CITY OF ALBUQUERQUE

RE: **700 Tijeras**
700 Tijeras Ave NW
Grading and Drainage Plan
Engineer's Stamp Date: 7/15/19
Hydrology File: K14D117

Based on the submittal received on 7/15/19, the Grading and Drainage Plan cannot be approved for Building Permit until the following corrections are made:

Sheet:
Grading and
Drainage Plan

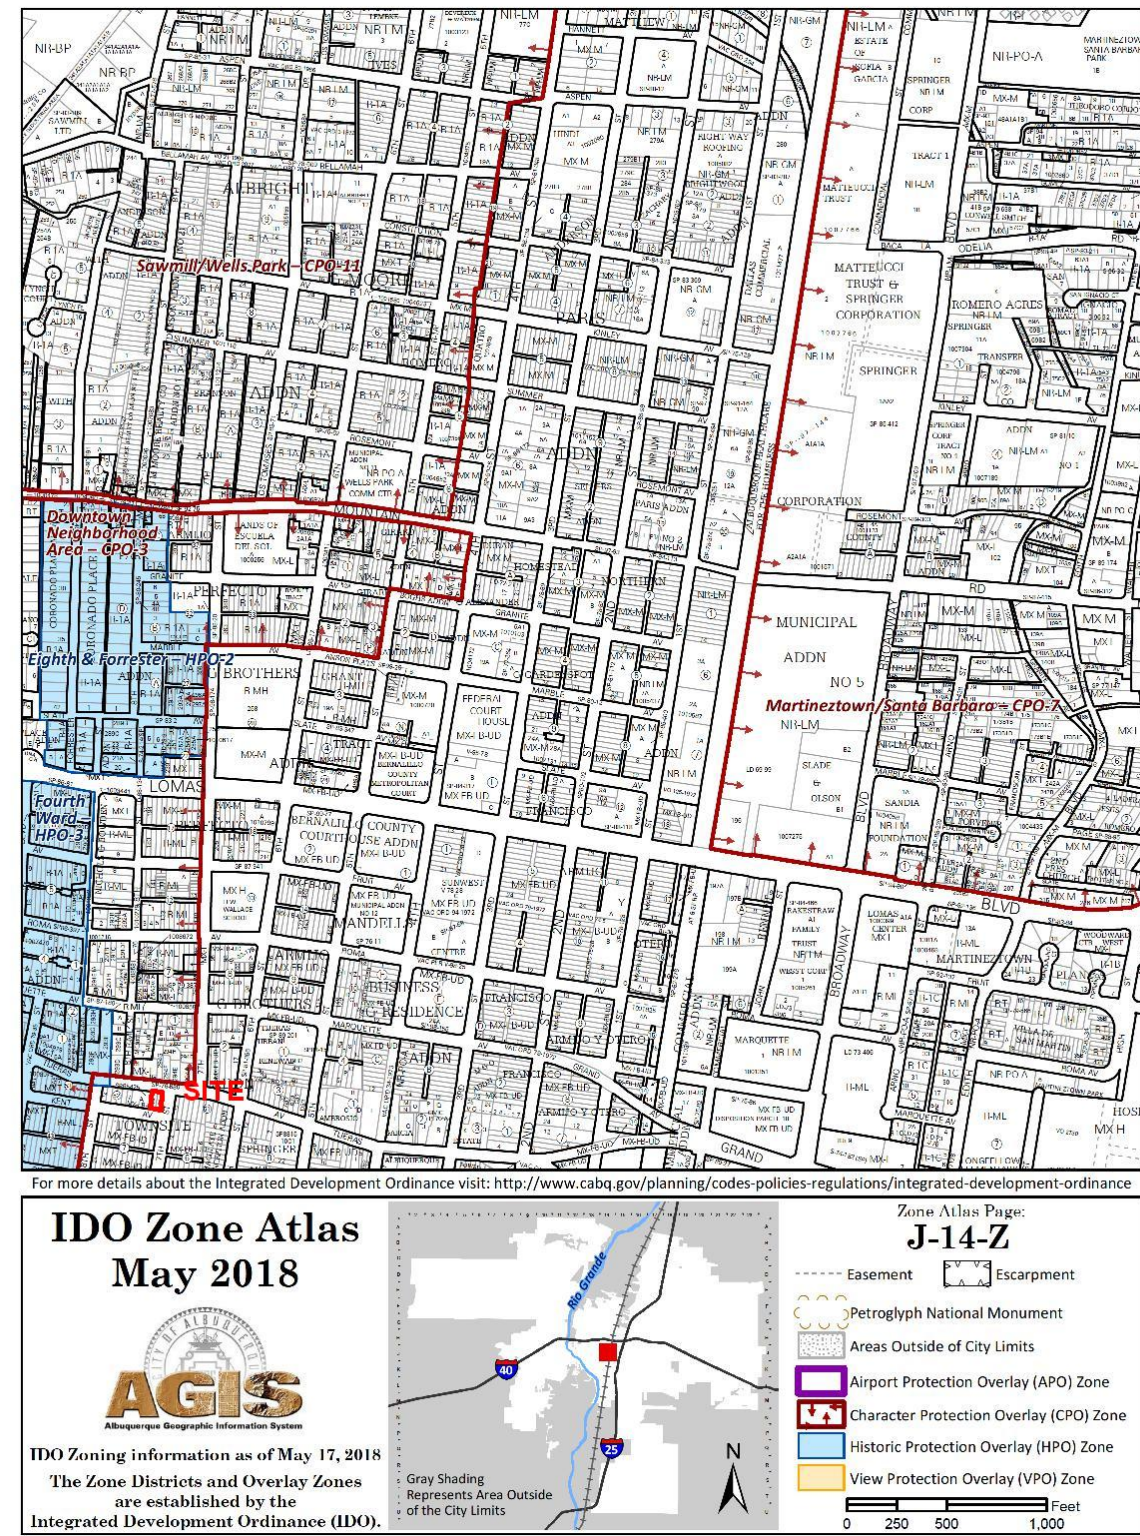
1. The temporary benchmark needs to be tied to a permanent monument, preferably part of the Albuquerque Geodetic Reference System (AGRS).
2. The drawing needs to be scaled to a common-use engineer's scale (not architect's) such as 1"=20' or 1"=10'.
3. For Information. This project will require a revocable permit for the balconies overhanging the ROW. Please contact the City Engineer (Shahab Biazar, sbiazar@cabq.gov) for more information.
4. Because these corrections are minor, the administrative resubmittal fee of \$40 may be used. Please include a copy of this letter when resubmitting in order to receive the reduced fee.
